Local Policing Support Team

Our Ref: LM/ARU/20/23A

RE: Land at Stakers Farm North End Road Yapton

Thank you for your correspondence of the 20th August 2020, advising me of a planning application for Approval of reserved matters following outline approval Y/44/17/OUT for the erection of 70 No. dwellings, public open space, play area, drainage & landscaping. This application affects the character & appearance of the Main Road/Church Road Yapton Conservation Area & affects the setting of Listed Buildings at the above location, for which you seek advice from a crime prevention viewpoint.

PLOTS
51-56

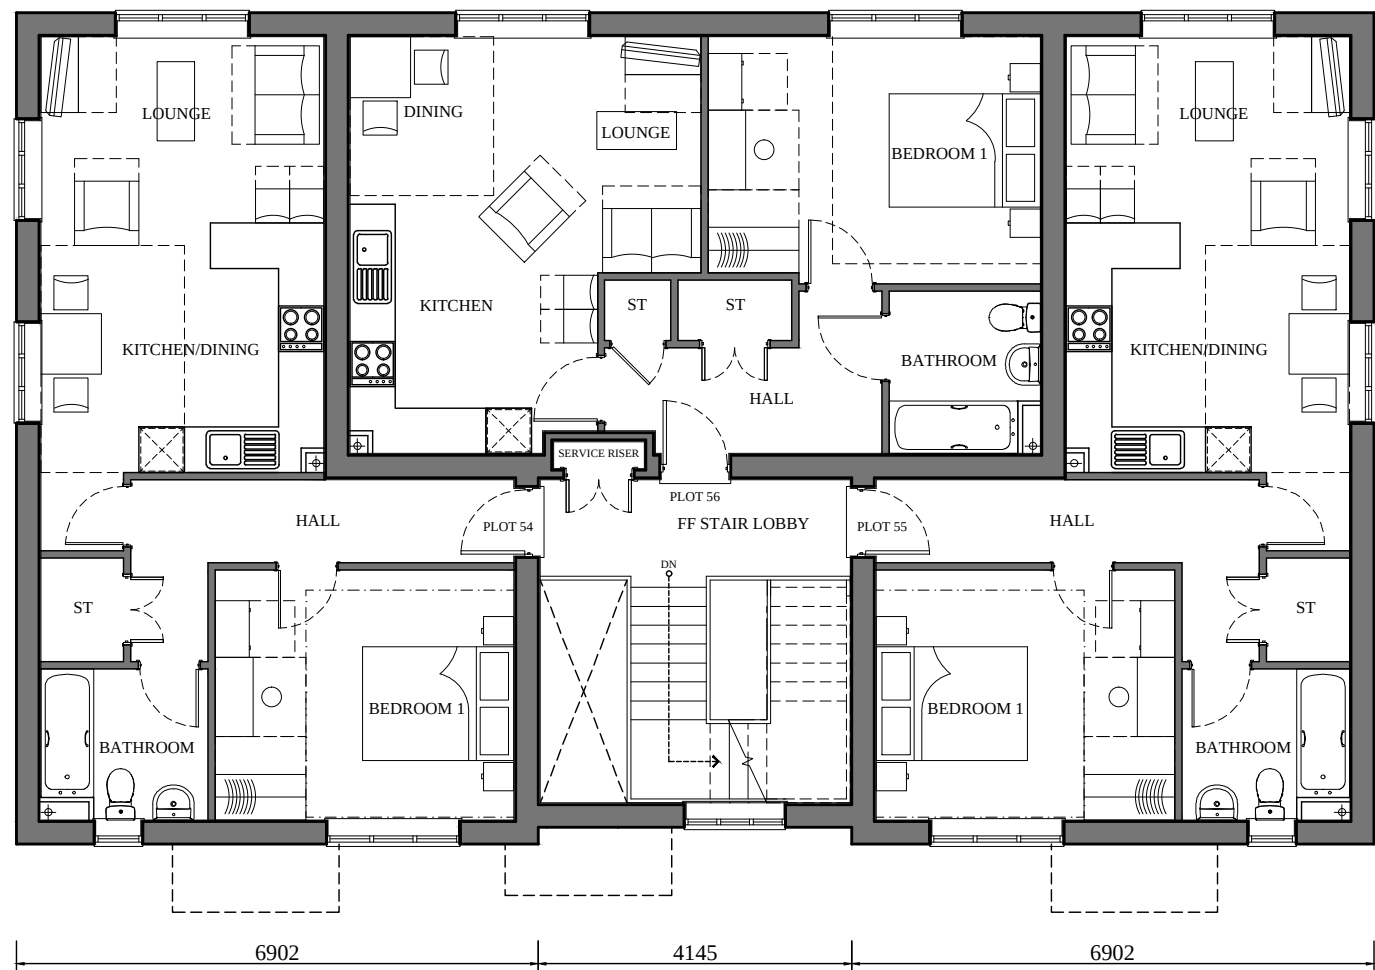
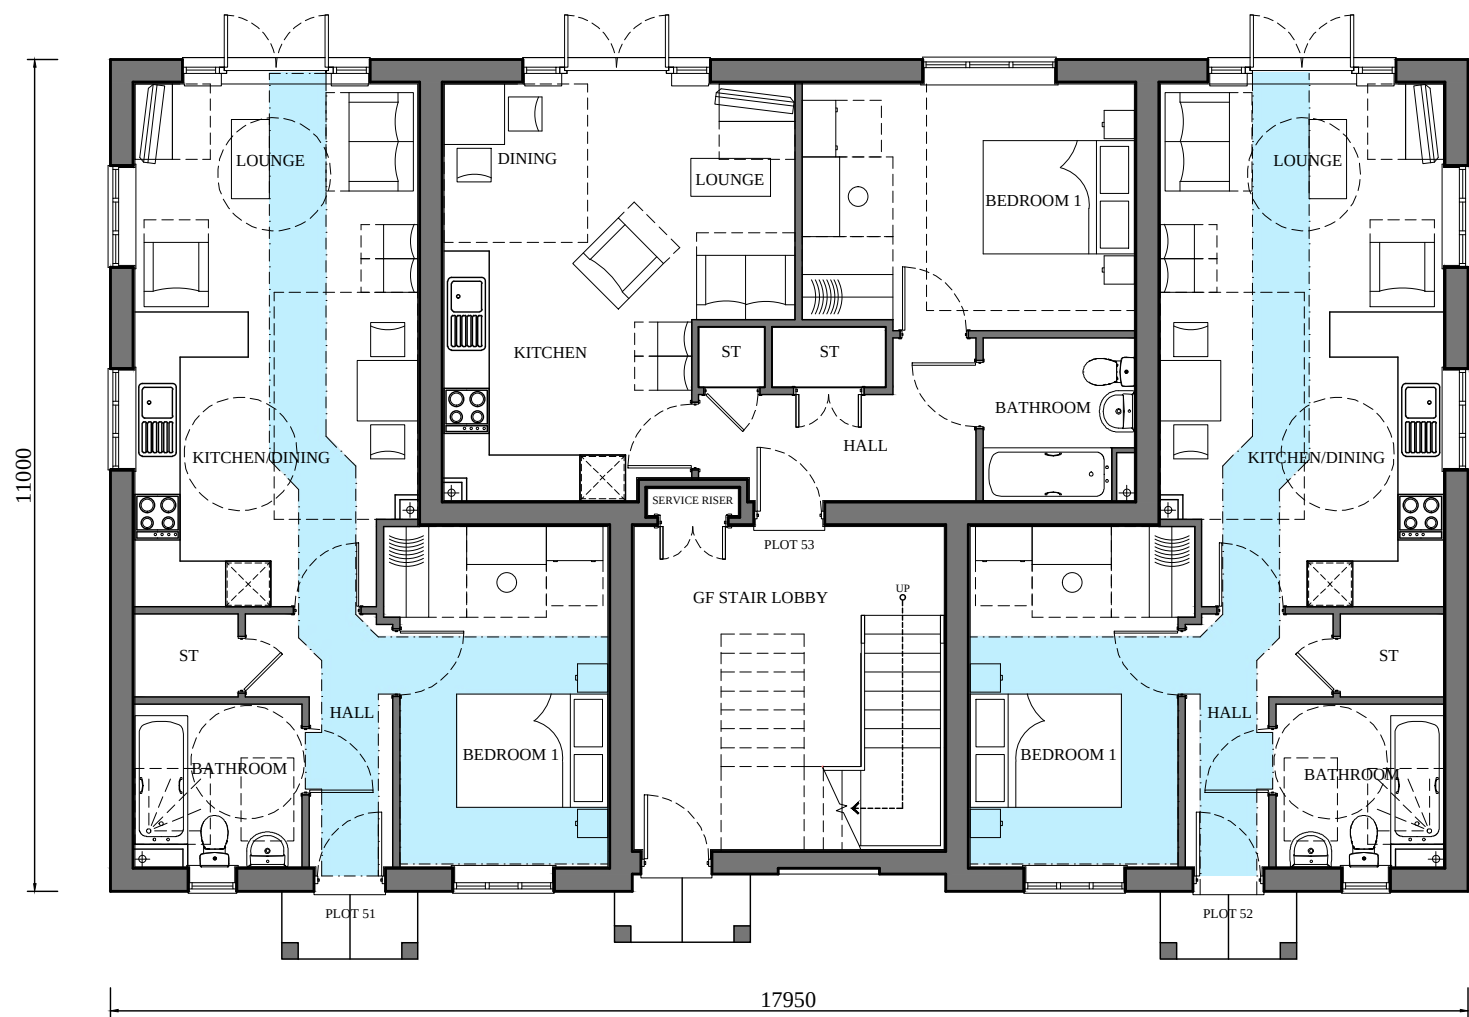
With regards to plots 51-56 which are the 1 bedroom flats from a crime prevention perspective it will be imperative that access control is implemented into the design and layout to ensure control of entry is for authorised persons only. SBD recommends that all communal door-sets serving 5 or more dwellings or bedrooms should have visitor door entry system or access control system to enable management oversight of the security of the building i.e. to control access to the building via the management of a recognised electronic key system. It should also incorporate a remote release of the primary entrance door set and have audio visual communication (preferably colour) between the occupant and the visitor. I refer the applicant to SBD Homes Version 2 2019 Chapter 27 paragraphs 27:1 through to 27:28.

Tradesperson or timed release mechanisms are not permitted as they have been proven to be the cause of antisocial behaviour and unlawful access to communal developments.

Additionally, I recommend the postal arrangements for the flats is through the wall or externally mounted secure post boxes. I strongly urge the applicant not to consider letter apertures within the flats' front doors. The absence of the letter aperture removes the opportunity for lock manipulation, fishing and arson attack and has the potential to reduce unnecessary access to the block.

PROJECT NUMBER:	PLOT DATE:
DD427	28.07.2020
DRAWING SCALE:	APPROVED BY:
1:50	PD
PAPER SIZE:	DRAWN BY:
A1	JT
DRAWING TITLE	
Play Equipment Plan

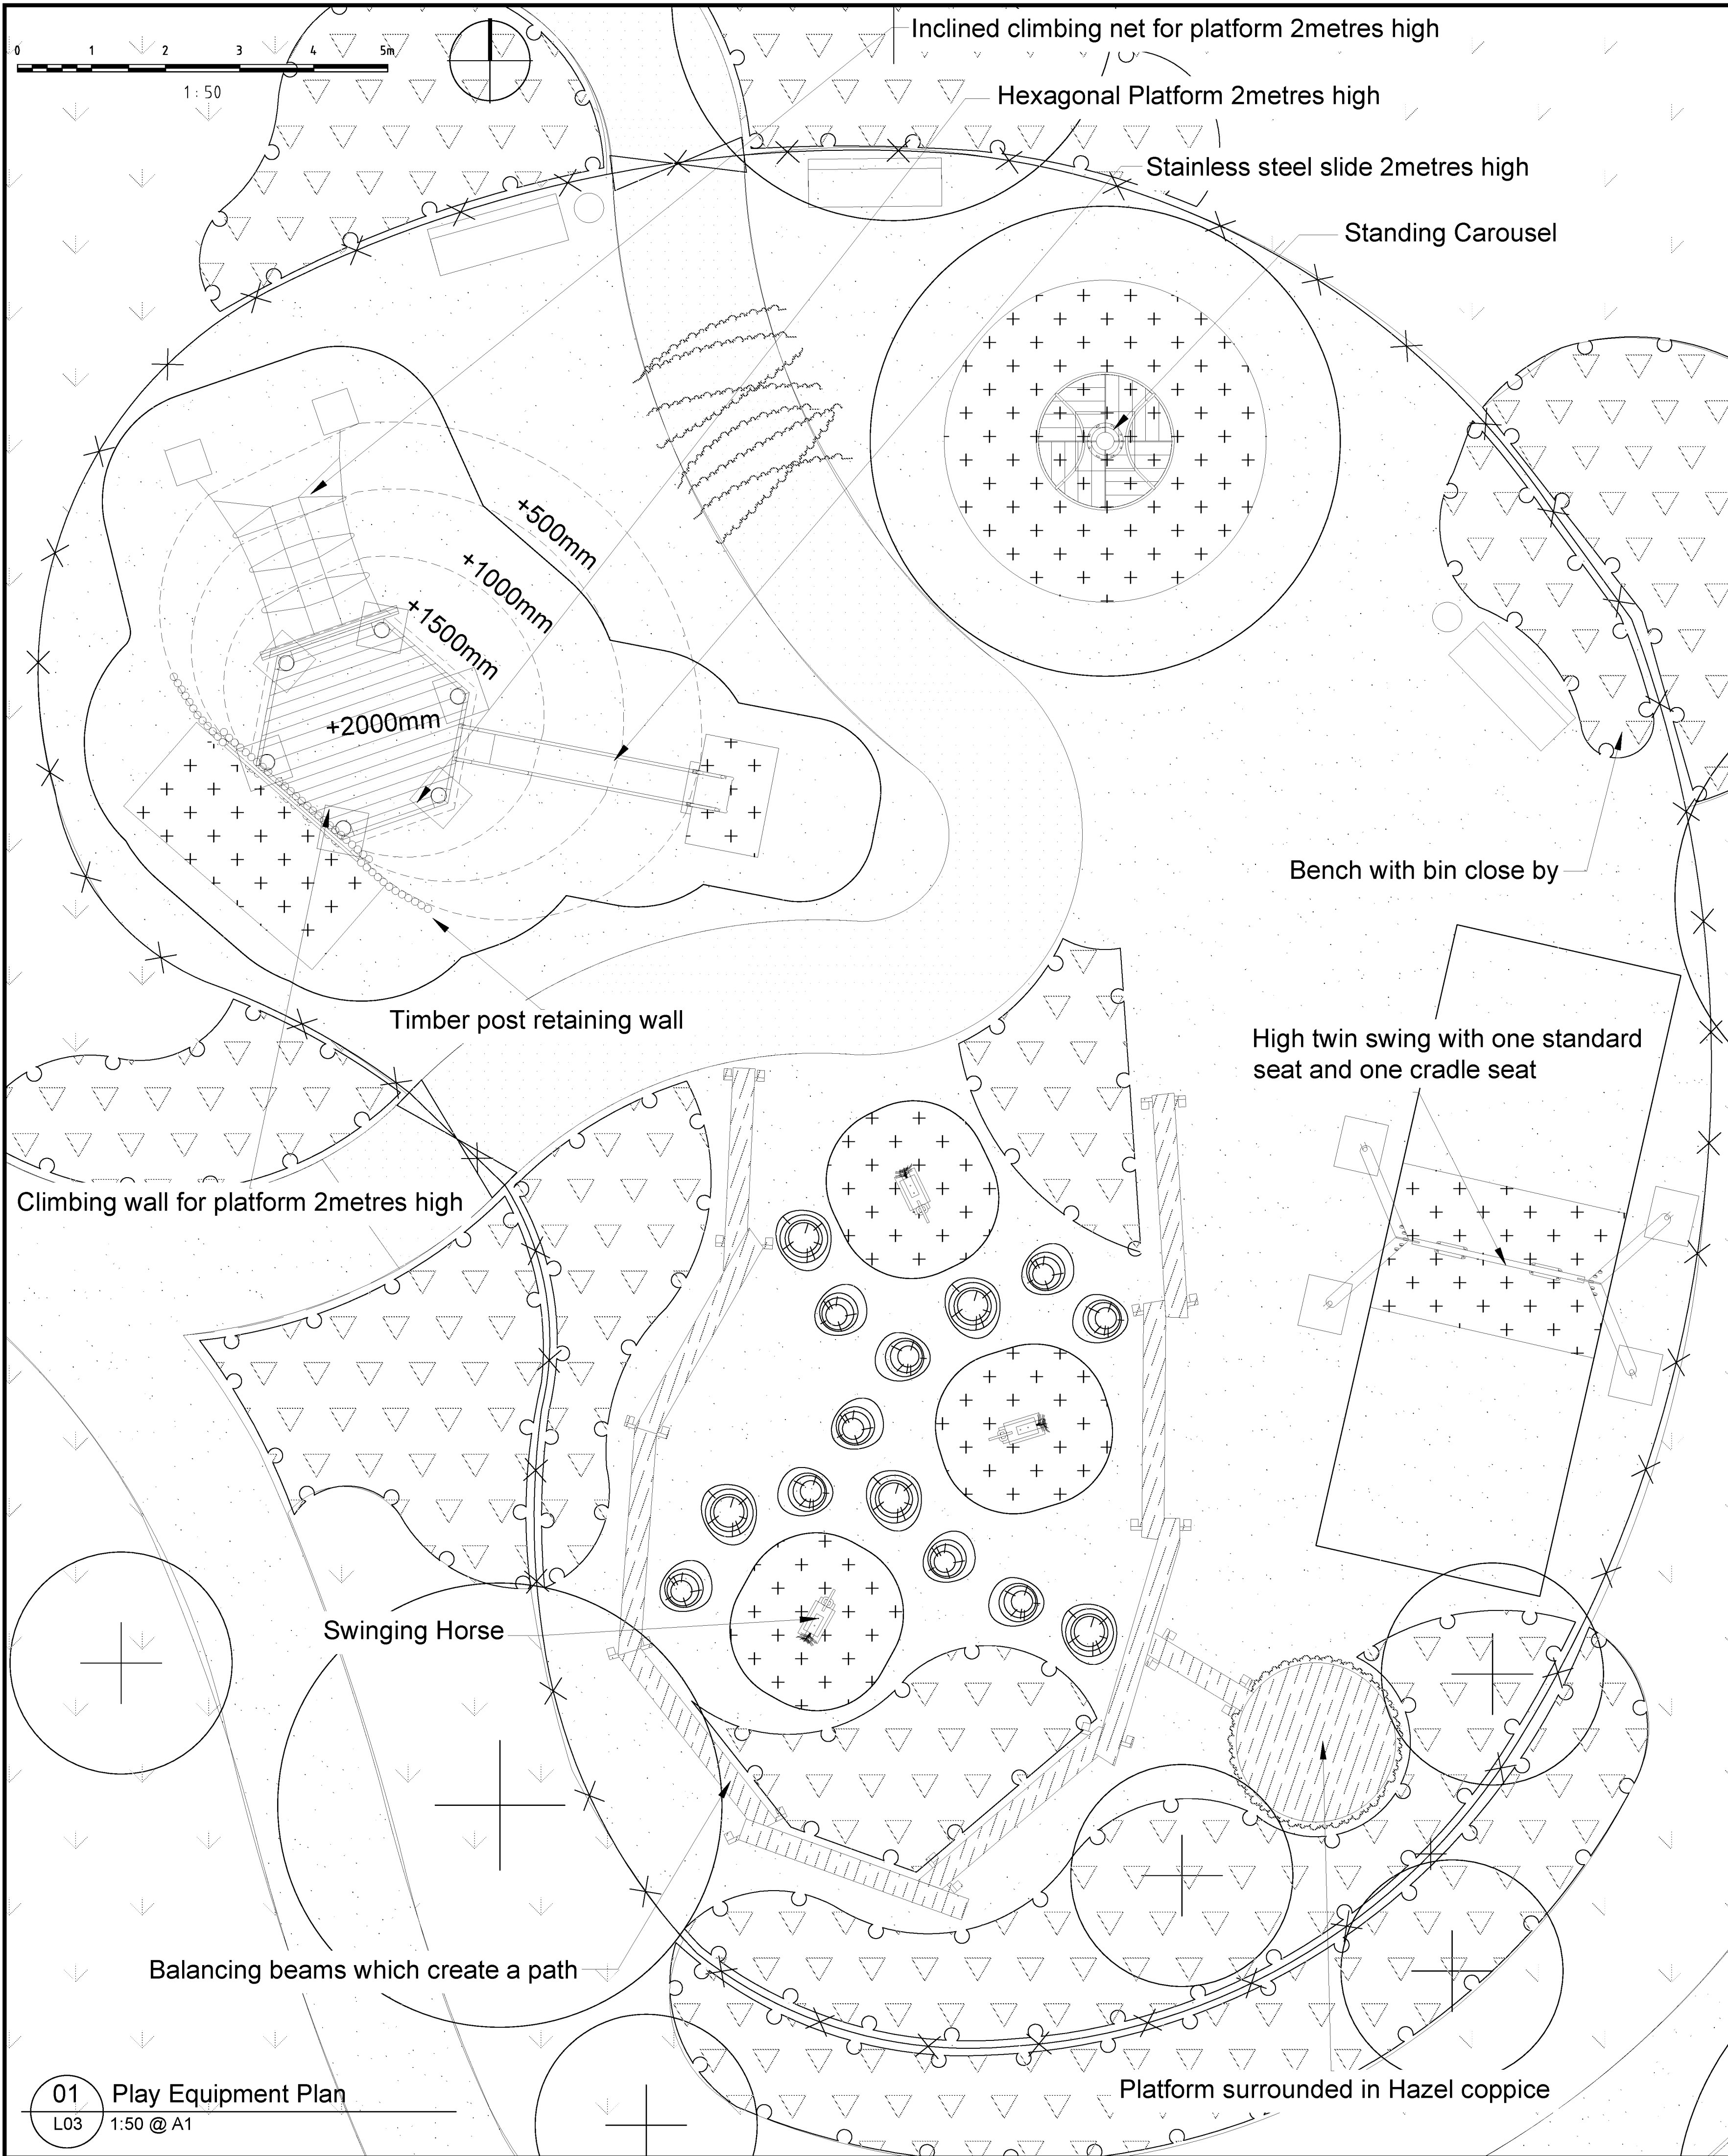
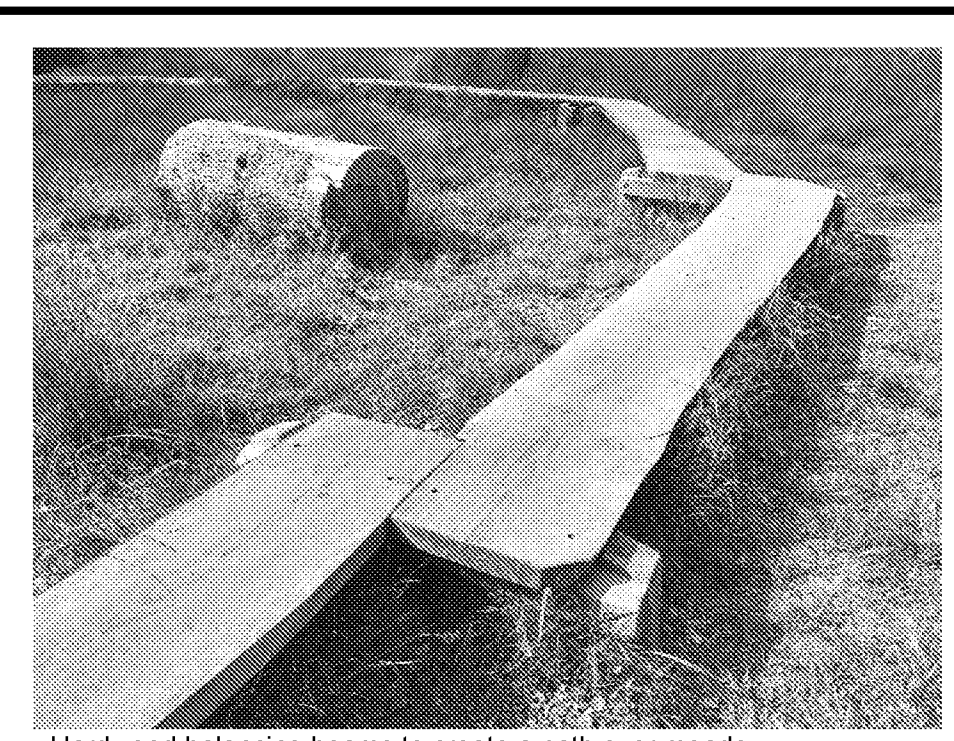
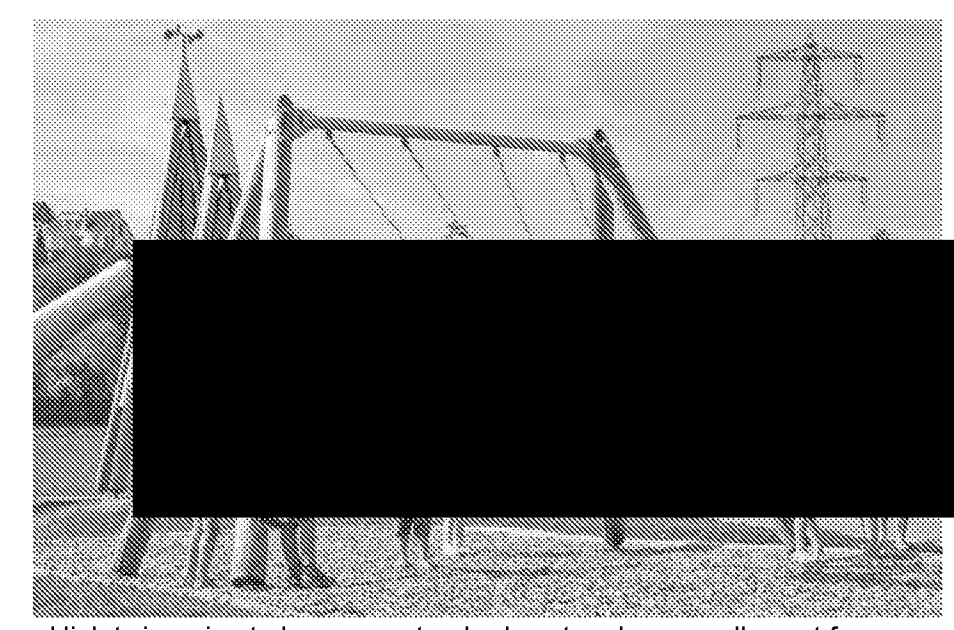
With regards to the LEAP - areas of play should be situated in an environment that is stimulating and safe for all children, be overlooked with good natural surveillance to ensure the safety of users and the protection of equipment, which can be vulnerable to misuse. They should be designed to allow natural surveillance from nearby dwellings with safe and accessible routes for users to come and go. Boundaries between public and private space should be clearly defined and open spaces must have features which prevent unauthorised vehicular access. This will be of particular pertinence to this application as the design and access statement states that the majority of visitor parking will be allocated close to this area.

I would ask that when consideration is given to the eventual location that it is surrounded with railings with self-closing gates to provide a dog free environment.
